**Housing Strategy and Development Team
Housing Services
Planning Application Comments**

Planning Application Number: 21/03639/F - Revision

Site Name: Os Parcels 6741 And 5426 West Cricket Field North, Wykham Lane, Bodicote

Date of Comments: 18/02/2022

House Type Planning Drawing
House Type: Type 50 (Semi-Detached)
Floor Plans - Sheet 1 of 2

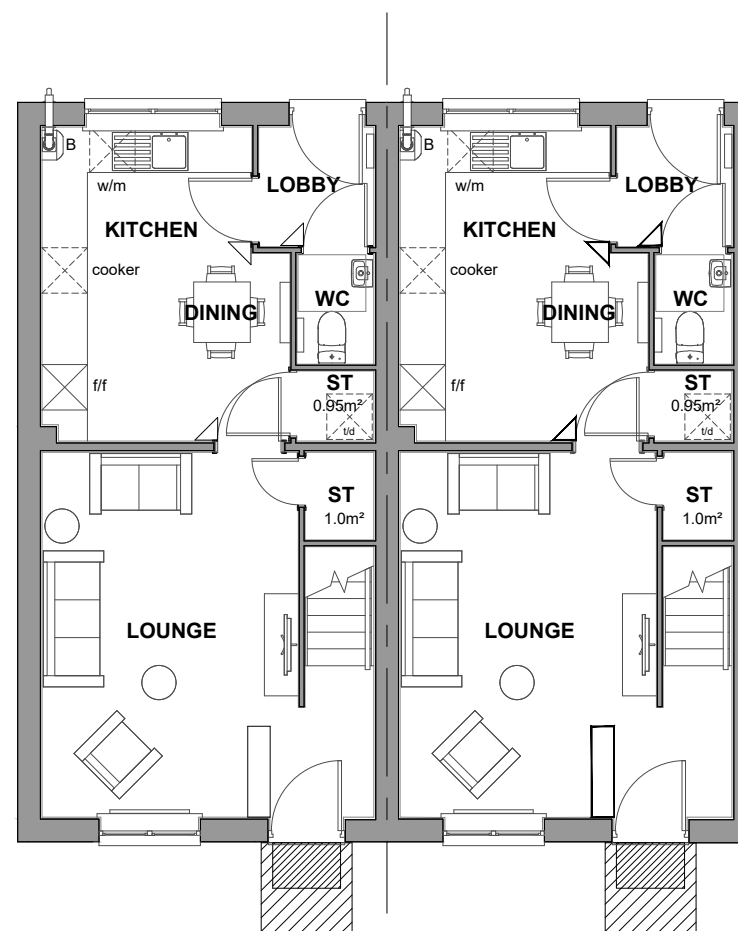
1. The dimensions for property type SH52 (plots 17,18 & 19) to be amended to NDSS dimensions for 3-bed 5-person dwellings, ie a minimum GIA of 93m² or if possible, 3-bed 6-person dwellings with a minimum GIA of 102m² or a mix of both.
2. The plans for property type T50 (plots 95, 96, 97, 98) to be amended to NDSS dimensions for 2-bed 4-person dwellings ie a minimum GIA of 79m².
3. 50% of all rented dwellings to meet the requirements of M4(2) Category 2: Accessible and Adaptable dwellings. We would request that plans are submitted showing the dimensions and features which will constitute compliance with these standards.

The revised plans show that type T50 dwellings have now been amended to 81.4m² which complies with NDSS.
